MIDDLETON STONEY PARISH COUNCIL RESPONSE

to APPLICATION 18/00825/HYBRID : HEYFORD PARK MASTERPLAN

WALKING AND CYCLING STRATEGY

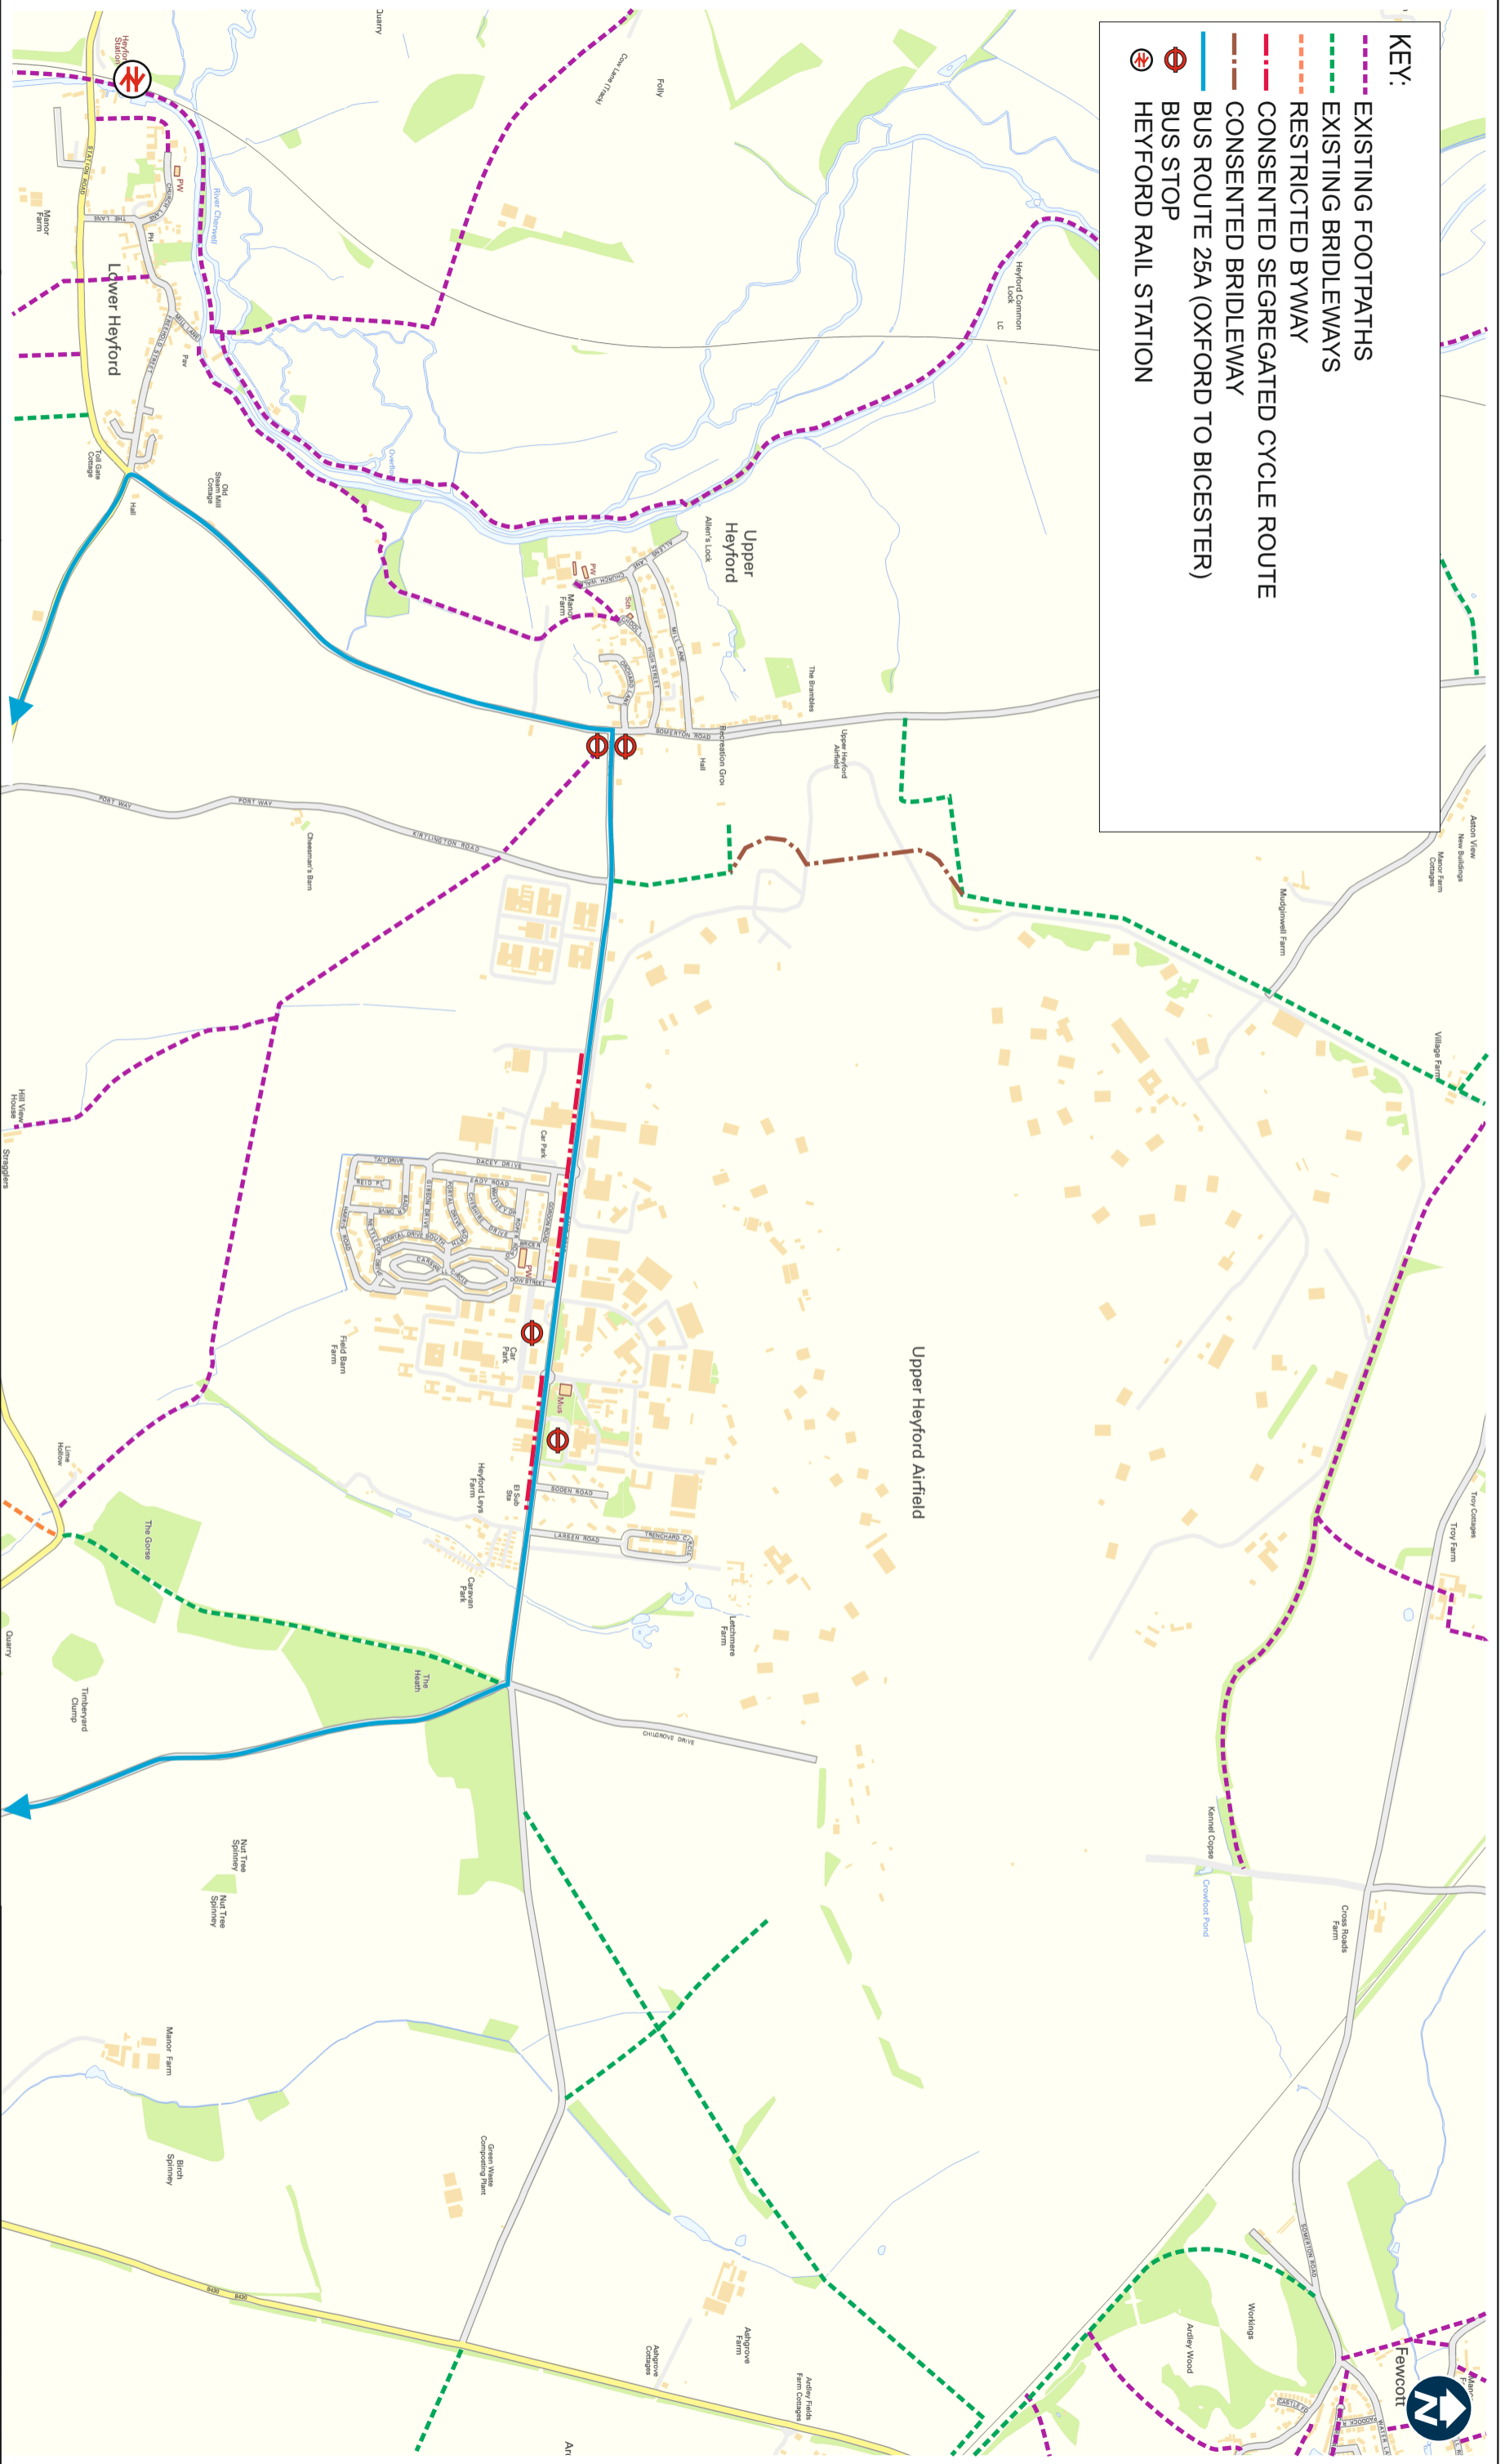
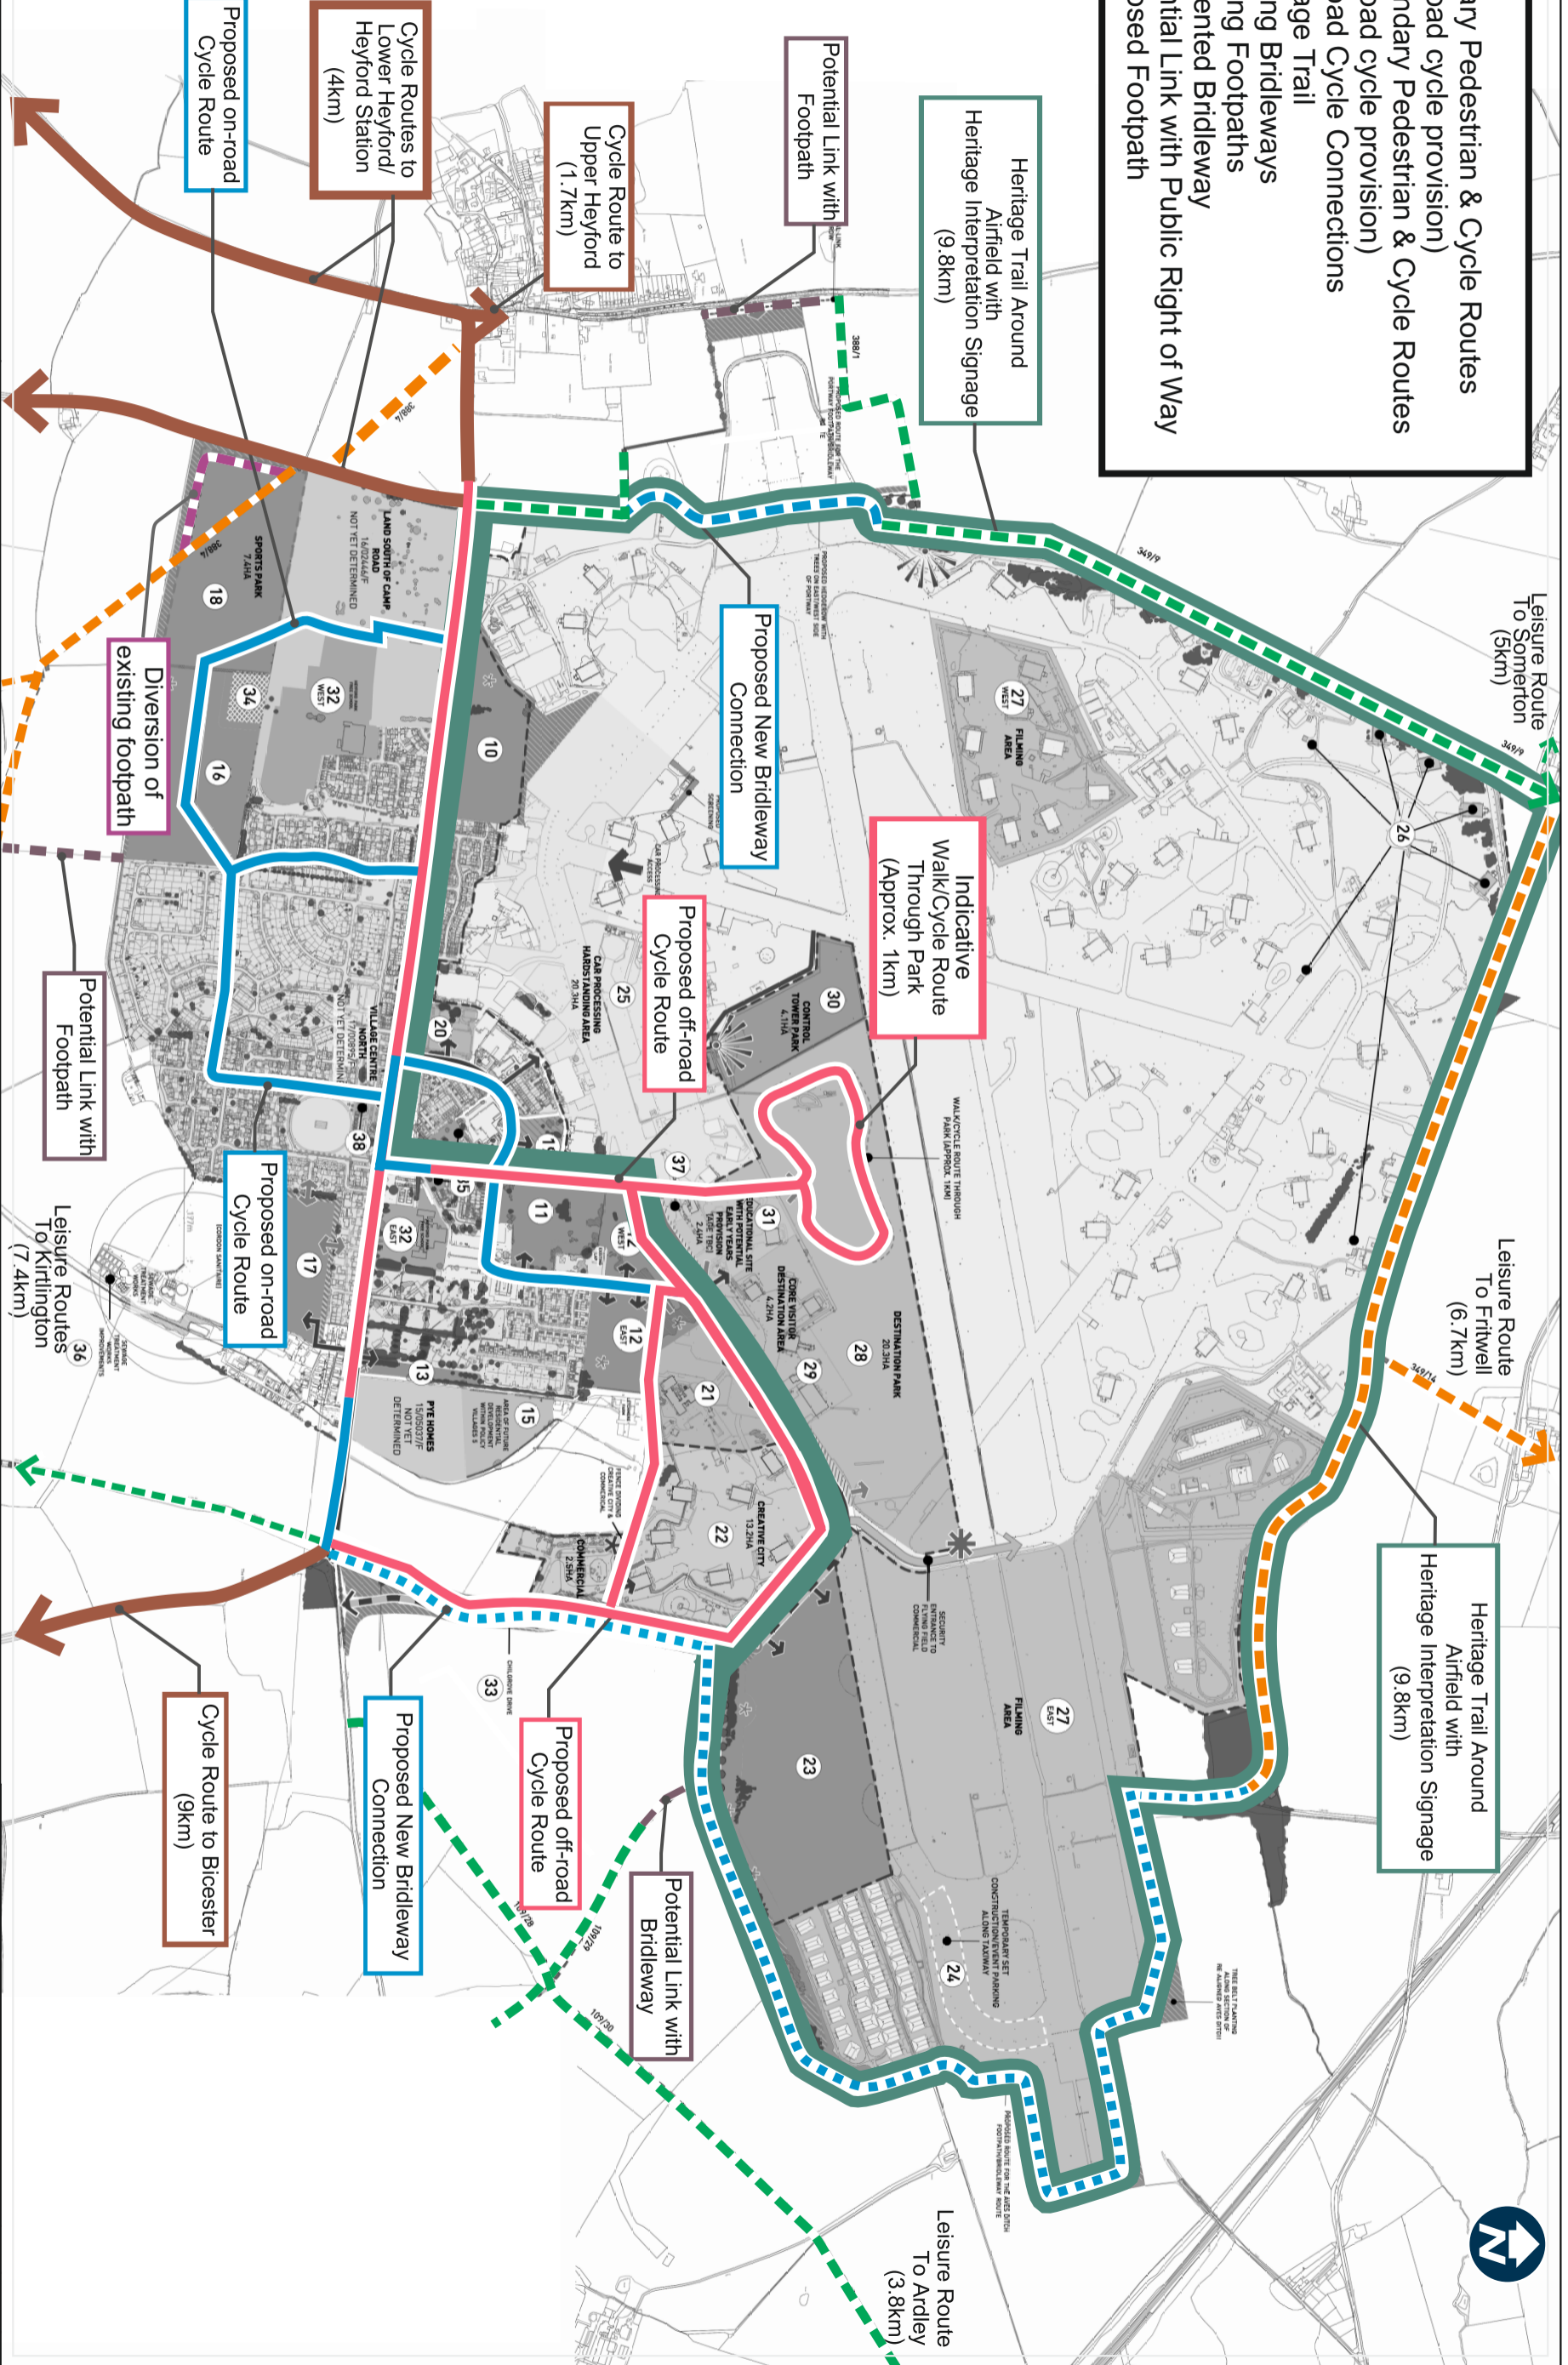
Again this is welcome in principle but ignores the fact that cyclists will be forced to ride flanked closely by large HGVs as well as large numbers of cars through a very narrow and congested junction in Middleton Stoney (as illustrated by the attached video). This is unlikely to encourage many new cyclists. We believe it would be much better to provide an off-road segregated cycle track on the whole route even if that necessitates narrowing the road for traffic in places.
